From: 
To: [Norfolk Vanguard](#)
Subject: Norfolk Vanguard Project. EN10079.
Date: 02 May 2019 20:33:20

The visual mitigation of the substation still seems vague.

Figure: 29.14b (2 of 2)
Viewpoint 2: Lodge Lane South

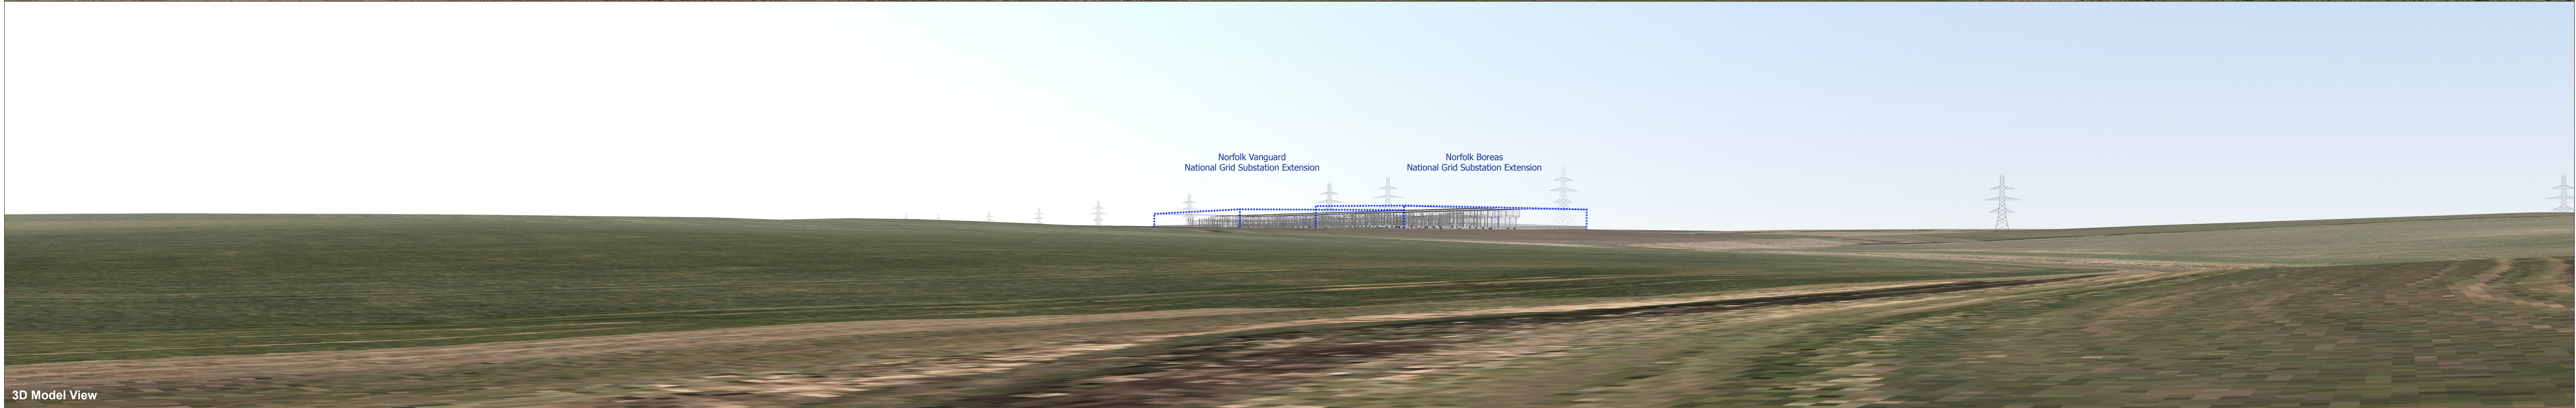
Viewpoint 2 Lodge Lane South scenario2. and viewpoint 3 Lodge Lane North scenario2 photomontages also concern me. Firstly they seem to be incorrectly titled Norfolk Boreas HVDC Substation, when they are I hope Norfolk Vanguard. Then comparing the views provided reveals an inconsistency that has a massive effect on the end result.

Starting with the lowest viewpoint, 2 Lodge Lane South, at stream level, at the ford, both converter halls are clearly visible. Then move to viewpoint 3 Lodge Lane North, which is up a considerable gradient, and closer to the Halls, and the east hall is barely visible, hidden behind a virtual 3D mound. On the same page as the 3D image, the baseline photograph does not show this mound, but the land consistently falling away from the lane. The baseline photograph looks correct, and the 3D image looks faulty. If the 3D images only are compared, starting again with viewpoint 2, the lane and gradient which you travel along to view point 3 is clear, and it is clear that viewpoint 3 would be a better vantage point to see the halls more completely and in more detail, but when you arrive at 3D image viewpoint 3. the land behind Lodge Farm has dropped 10m, and a mound has formed to

the left of the lane, both features make the view of the halls worse than viewpoint 2. and are nonexistent, and do not manifest as you travel up Lodge Lane. The subsequent mitigation montage looks based on the 3D image, which shows it seriously over effective, also taking into account the land rises 4-5m behind Lodge Farm, the 3D image looks, or is totally wrong, for whatever reason.
